WEST SUSSEX COUNTY COUNCIL CONSULTATION

TO:	Arun District Council FAO: Michael Eastham
FROM:	Stephen Gee WSCC - Highways Authority
DATE:	17 May 2019
LOCATION:	Boweries Barnham Road Chichester PO20 3RT
SUBJECT:	EG/22/19/OUT Outline application with some matters reserved for the erection of 28 No. dwellings, access, landscaping & associated works (resubmission following EG/42/18/OUT).
DATE OF SITE VISIT:	3/8/18
RECOMMENDATION:	No Objection
S106 CONTRIBUTION TOTAL:	£ See below for breakdown.

FIGURE 1.4

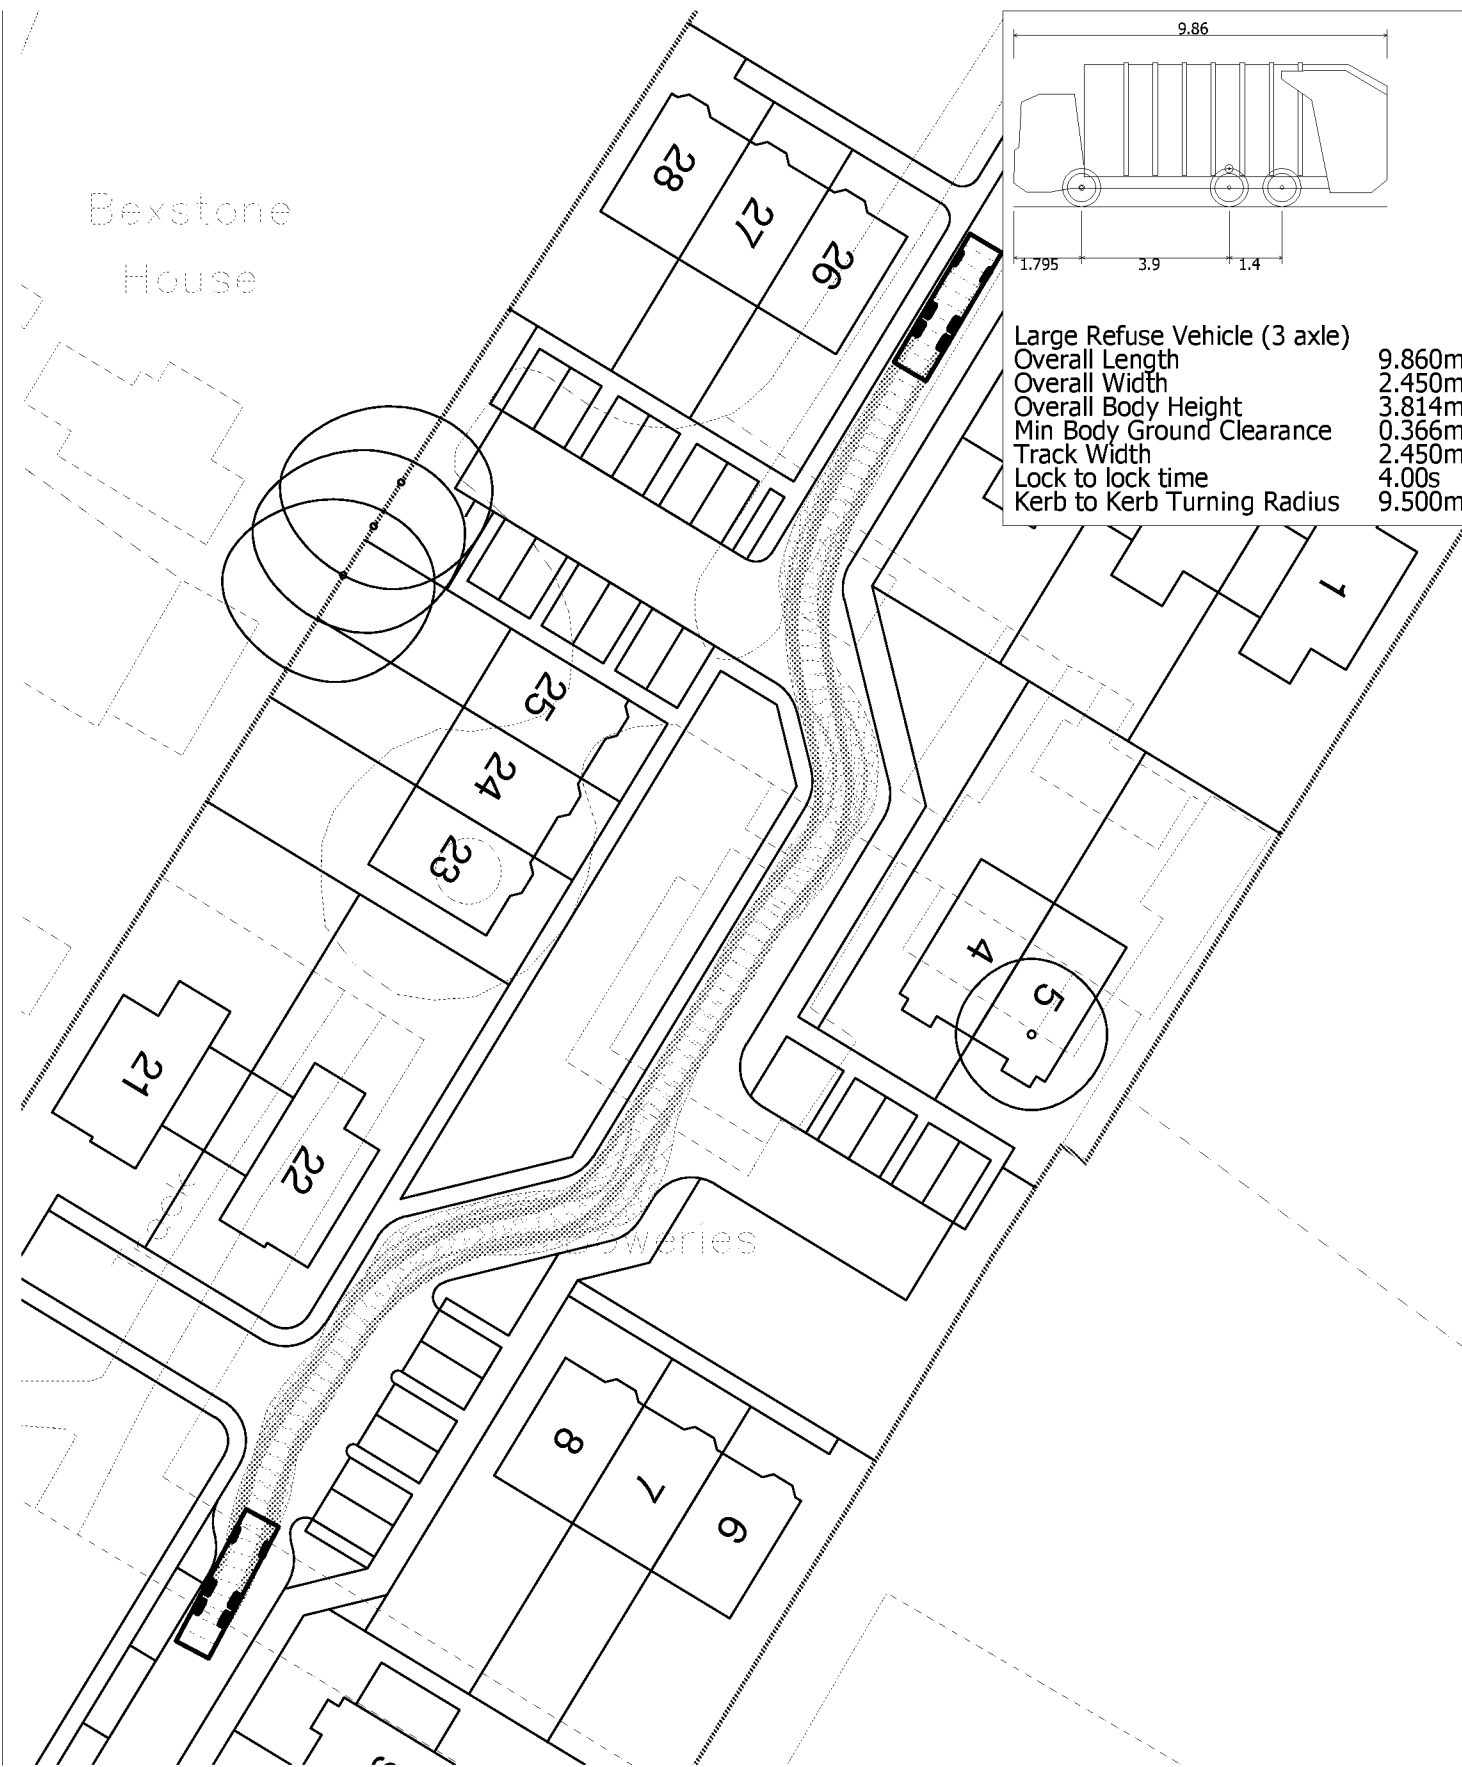
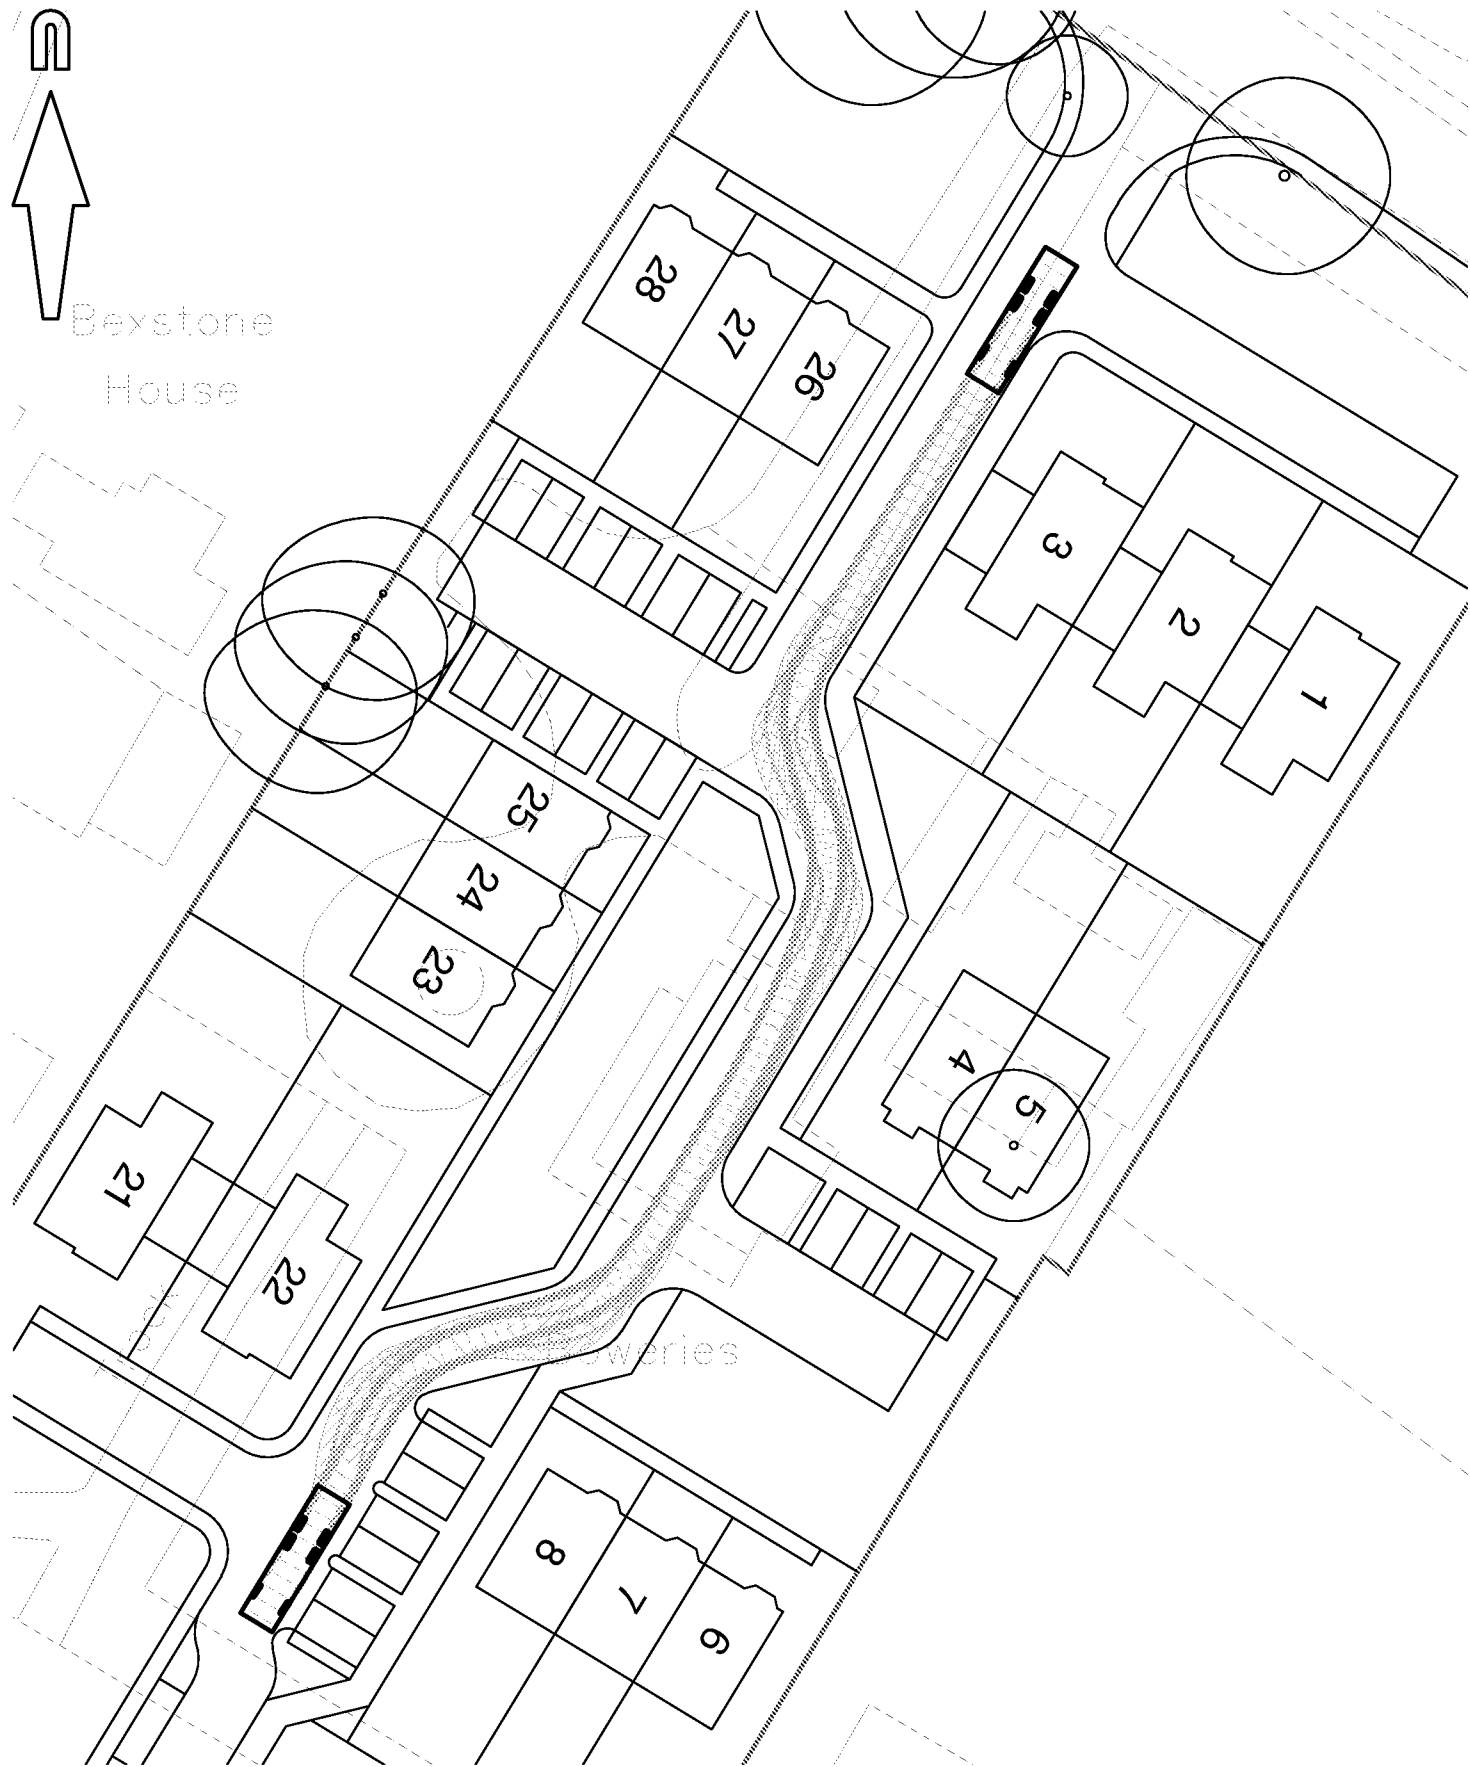
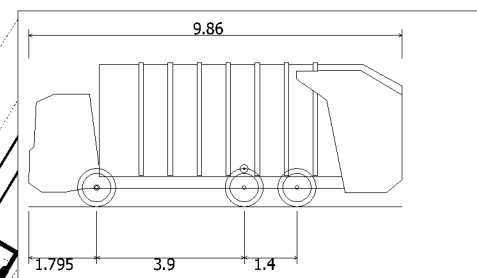
Additional vehicle tracking has been provided and is accepted.

client			
Domusea Limited			
project			
The Boweries Barnham Road Eastergate			
title			
Wider Development and Landscape Framework Plan			
date	scale @ A3	drawn	chkd
Jan 2019	1:1500	MRL	GBC
project no.	drawing no.	rev	
1815	1000	P01

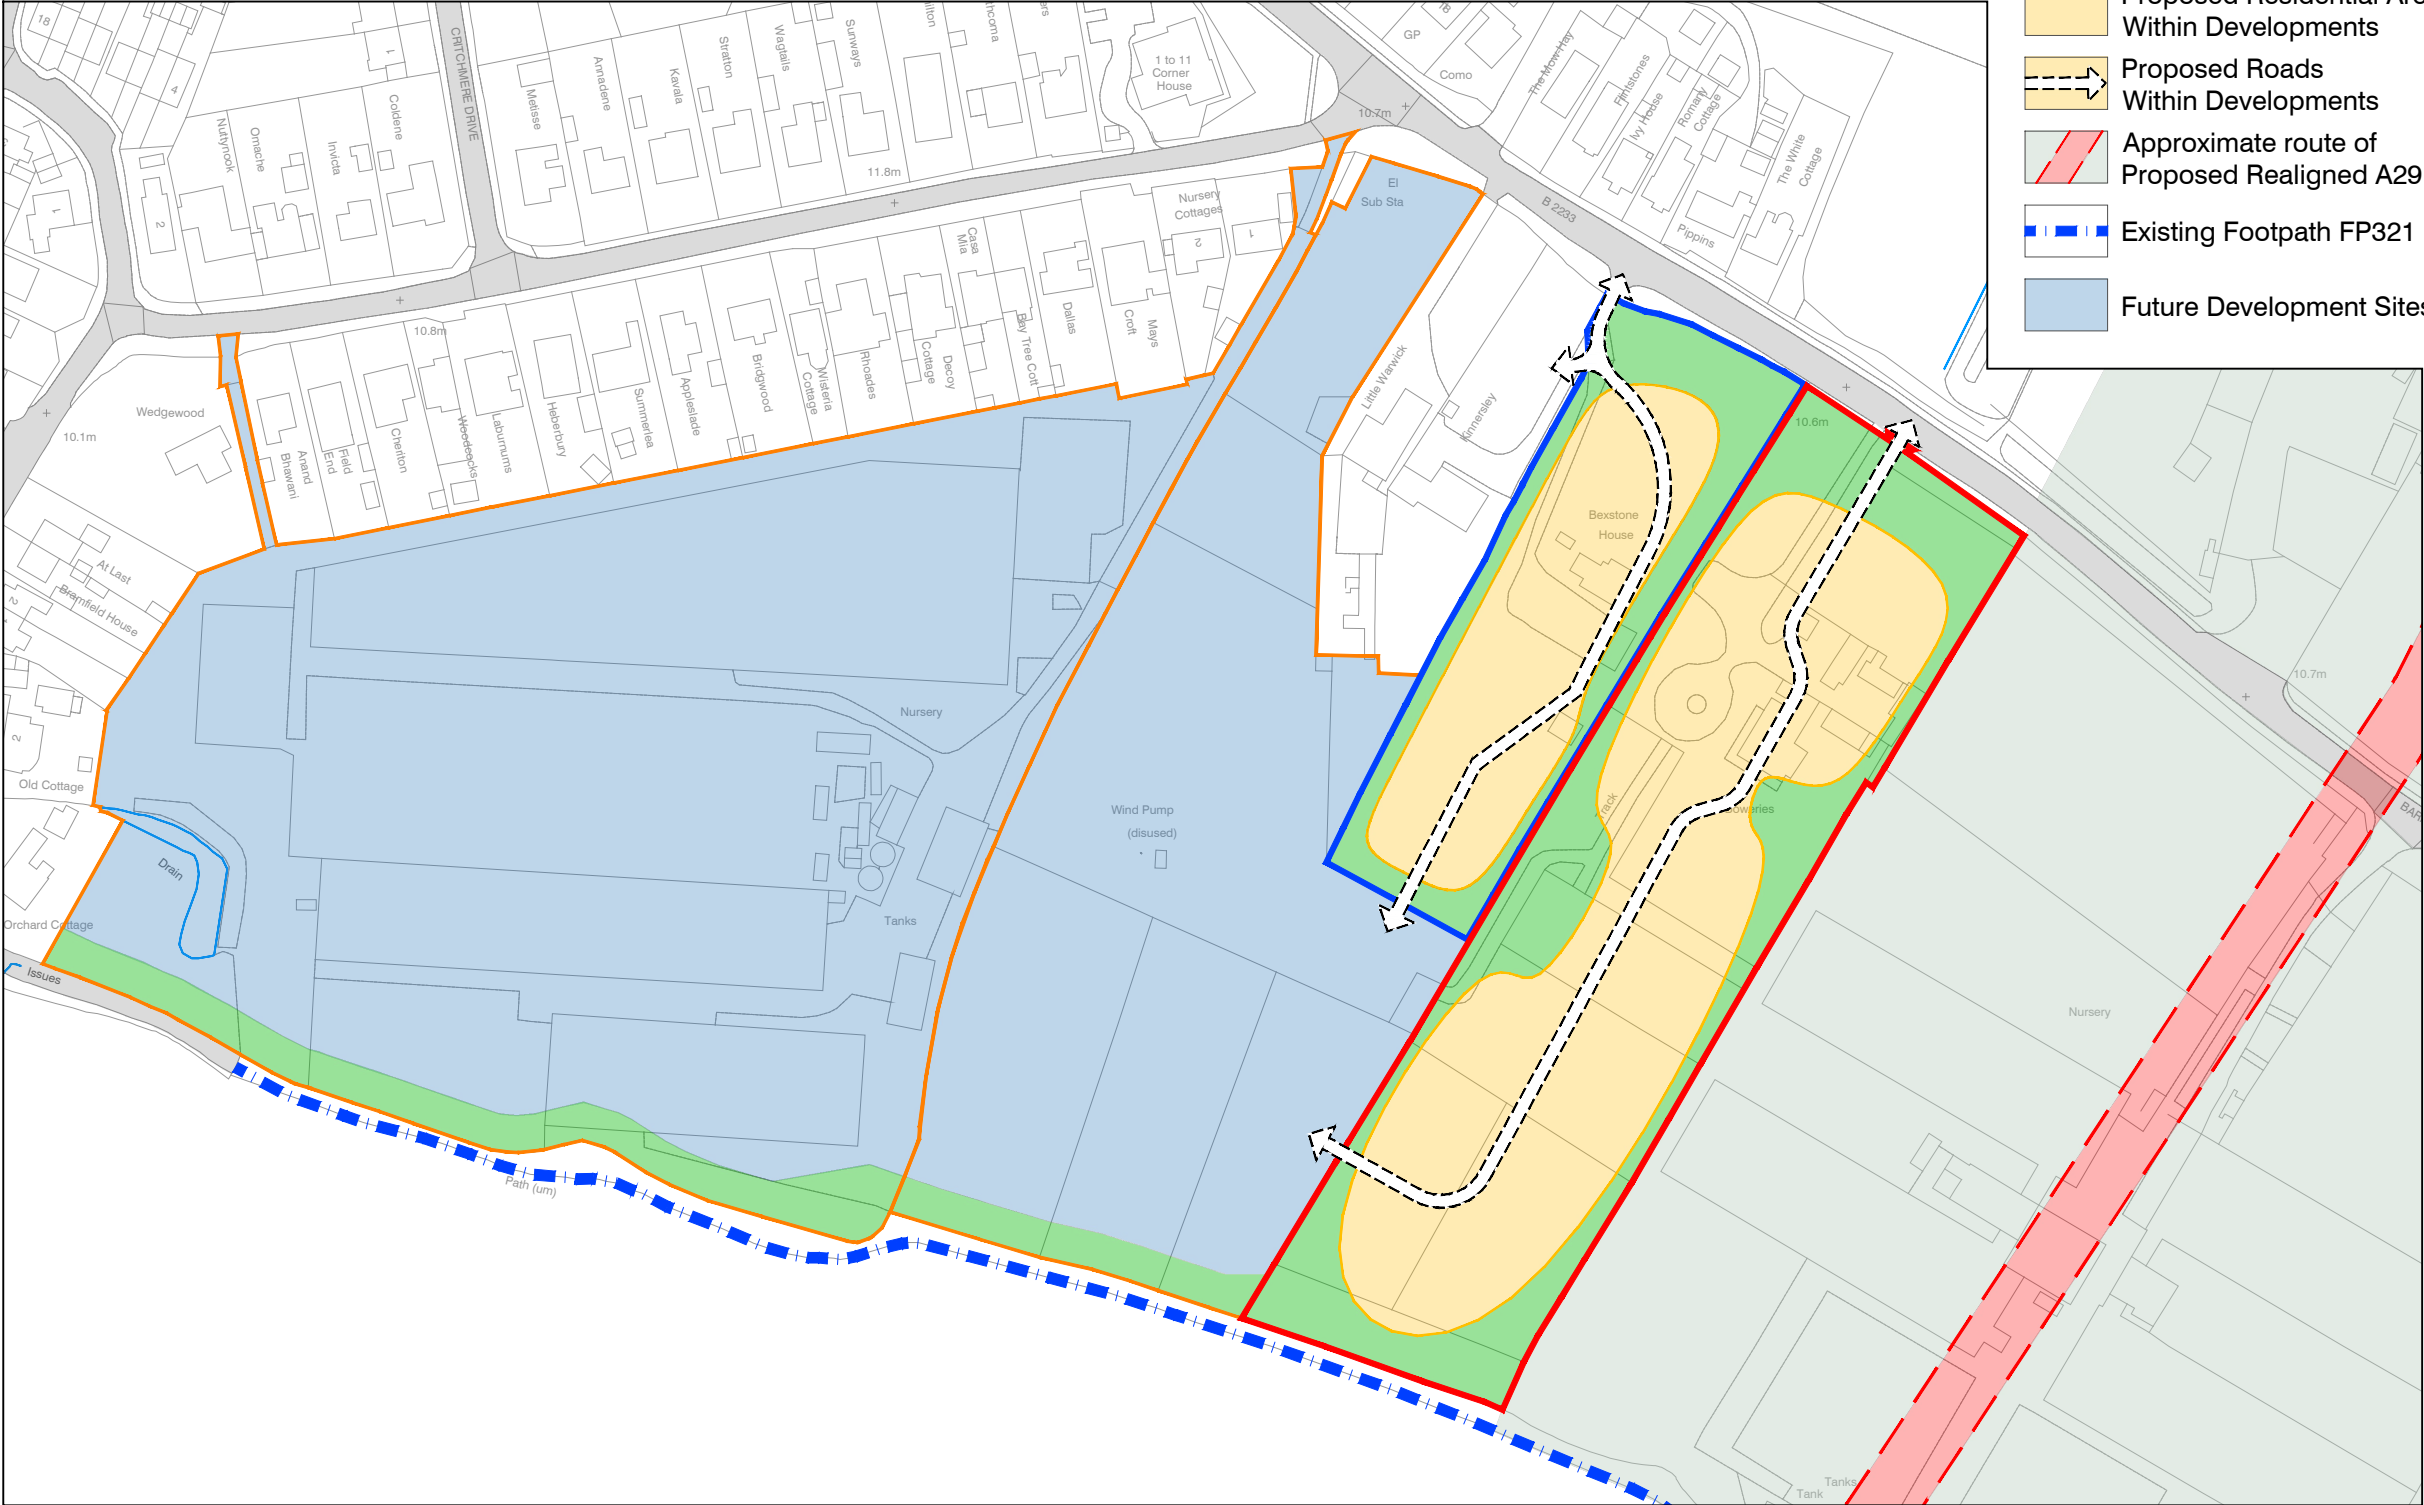
The revised proposed site layout plan shows a connection into neighbouring land via the southern turning head. A turning head/drive is also located close to the boundary of Bexstone House (also included within the strategic allocation and could provide future linkages.

Public Footpath 321 runs along the southern boundary of the site. The strategic landscape masterplan highlights a pedestrian link from the footpath into the development. The footpath is identified as a future cycle link within the WSCC walking and cycling strategy and as such the link into the development should be incorporated as and when layout is considered.
